FEDERAL AVIATION ADMINISTRATION INFORMATION

Xcel Energy understands that El Paso County requires a Determination of No Hazard from the Federal Aviation Administration (FAA). The new 345-kV double circuit transmission line will be constructed using steel poles between 105-140 feet above ground level, and poles will not exceed 199-foot maximum height (see Section 1.4.a of the 1041 Application Narrative for additional information). Xcel Energy will use the FAA hazard tool to determine any structures that require review by the FAA. Xcel Energy will file FAA Form 7460-1, Notice of Proposed Construction or Alteration, with the FAA following final design for any structures that require FAA review.

Figure 4: Typical Transmission Pole Configuration (Illustrative)

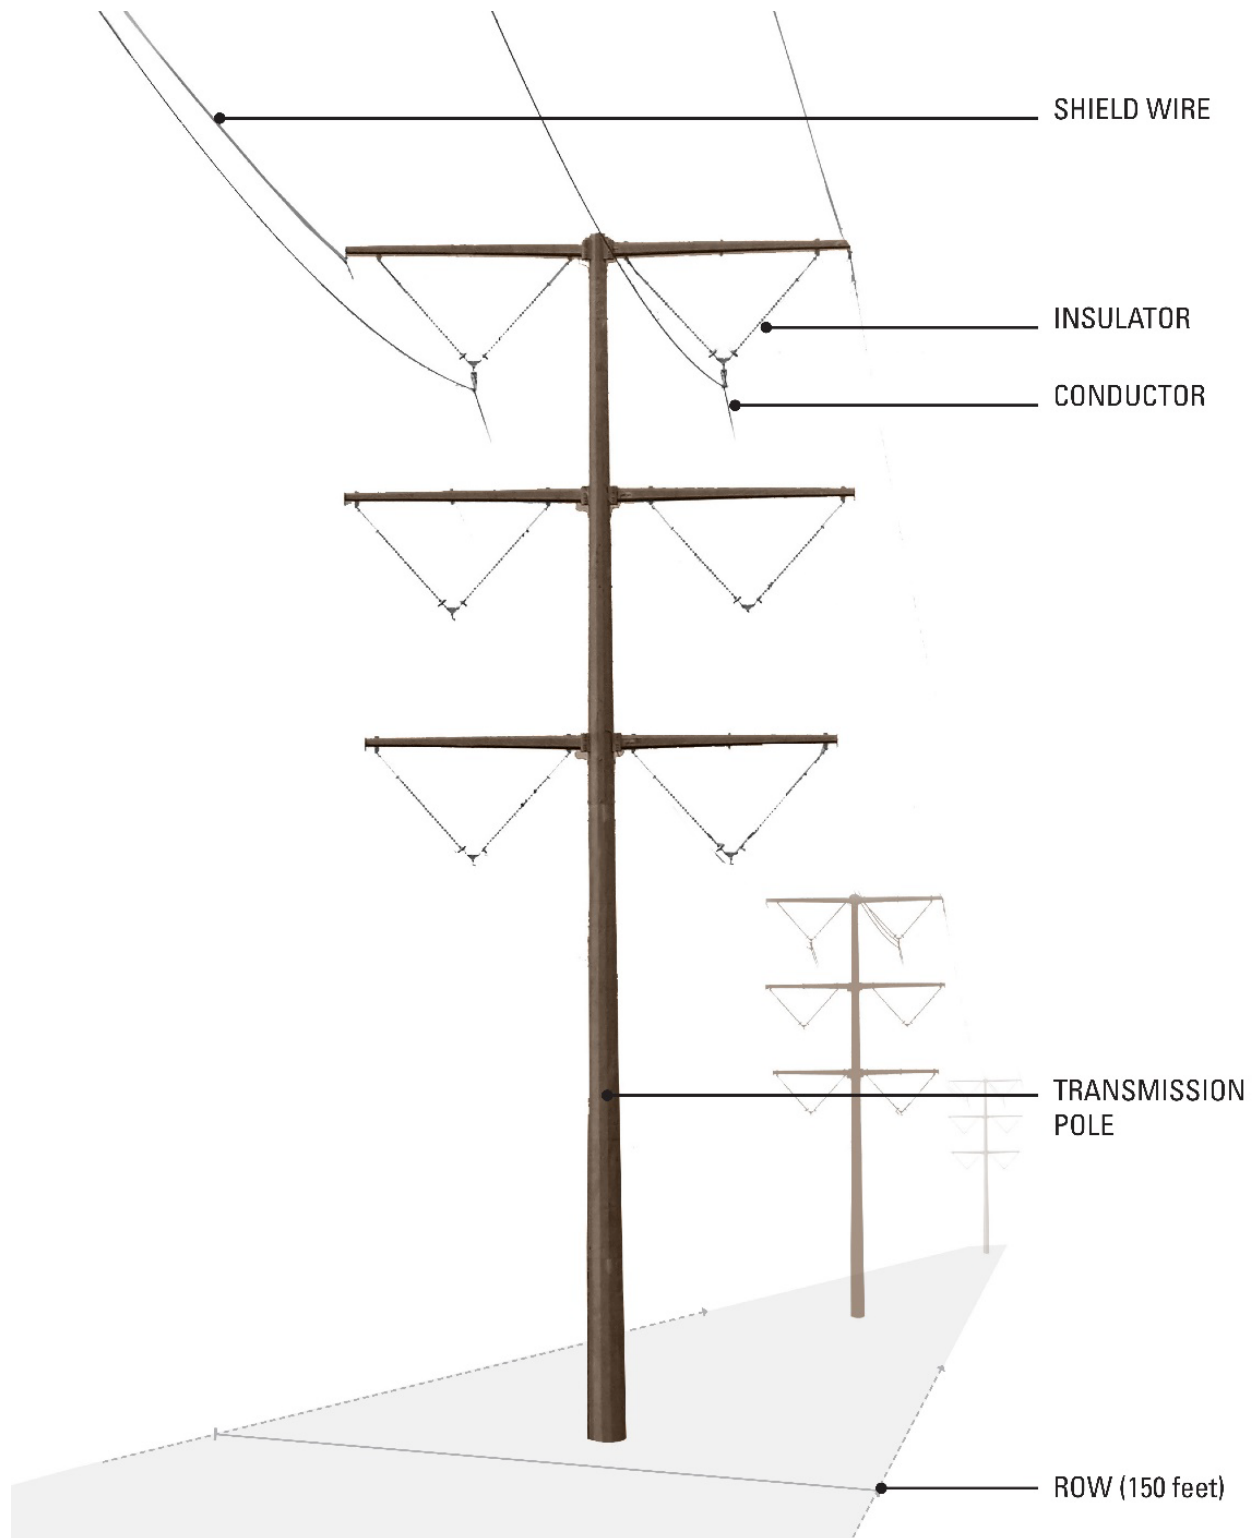
provide
correspondence from
FAA; this is not
correspondence
